Environmental Health Consultation Response

To	Harry Chalk
Date	26-02-2026
Planning Ref	LU/33/26/S73
Site Description	Flint Acre Toddington Lane Littlehampton West Sussex BN17 7PN
Date of Application	2026-02-10 00:00:00
Category	Planning Variation To Conditions
Recommendation	~~No Objection~~ ~~No Objection — with conditions~~ ~~Objection~~ Holding Objection

I have reviewed this application to vary conditions 2 layout and 3 noise protection.

Figure 3 Shows representative typical intermittent maximum noise levels across the site.

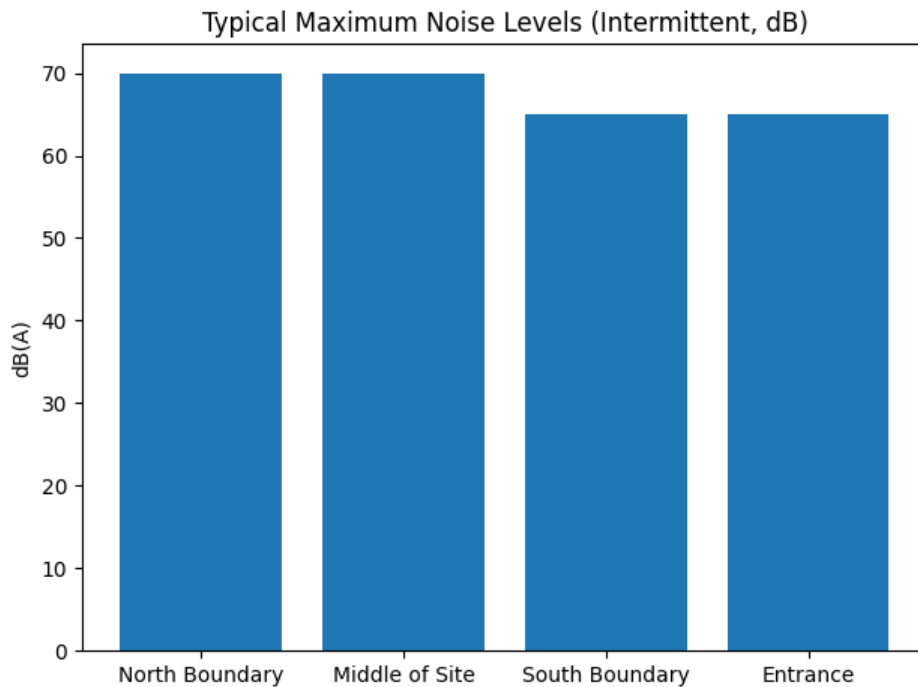
The report by ARCHItékton Architects Limited gives an indication of the existing noise climate but uses lots of averages and ranges which are not very specific and can hid the true impact of the adjacent commercial use. The noise report does not include any comparison to the current standards, as this is a commercial premises, we would expect to see a BS4142 assessment as the most appropriate standard. Noise from uses such as this can also contain low frequency noise, and while this may not be the case with this development, as this is not discussed and no frequency data is submitted, we cannot not sure.

Another area that needs clarifying, is the legal hours of use for the commercial use. It is very common haulage companies start early in the morning and work through to late at night, the submitted assessment only measures the noise between 07.00-09.00 and 11-13.00 which without knowing the hours of use of the commercial use we cannot be sure that this gives a reasonable assessment window.
